**KIRKLEES METROPOLITAN COUNCIL  
INVESTMENT & REGENERATION SERVICE**

**DELEGATED DECISION FOR APPLICATION FOR CERTIFICATE OF  
LAWFUL DEVELOPMENT**

Reference no.: 2025/CL/91156/E

Site: 364, Whitechapel Road, Scholes, Cleckheaton,  
BD19 6HH

Project -
SINGLE STOREY REAR EXTENSION
Client -
364 WHITECHAPEL ROAD, SCHOLES, CLECKHEATON. BD19 6HH. Mrs. G. Barnes
Title -
PROPOSED ROOF PLAN

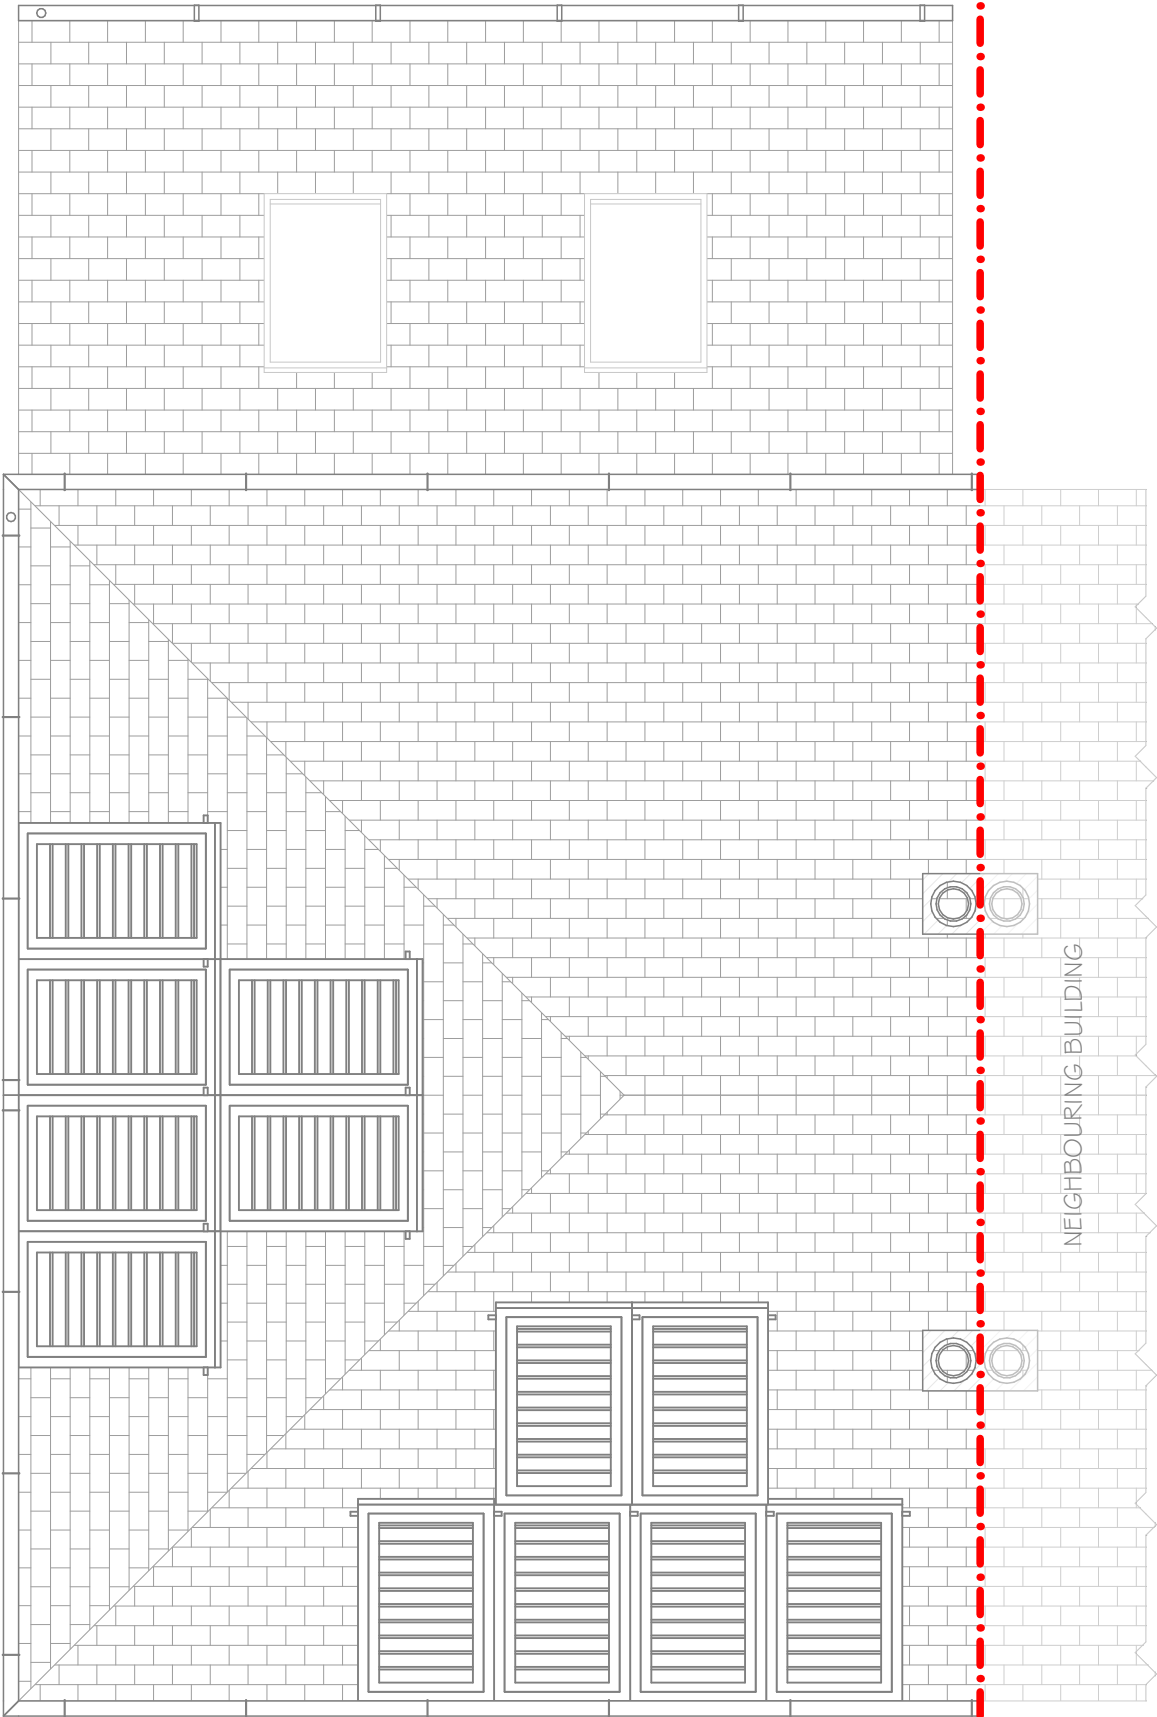
**Comment:** *The highest part of the extension would not exceed the height of the highest part of the roof of the existing dwellinghouse.*

**Comment:** *The dwelling is a detached property and the extension would not project beyond the rear wall of the original dwellinghouse by more than 3 metres. It would not exceed 4 metres in height.*

**Comment:** *The dwelling is not on article 2(3) land. The property is a detached dwelling and the proposed development would extend approximately 3 metres beyond the rear wall.*
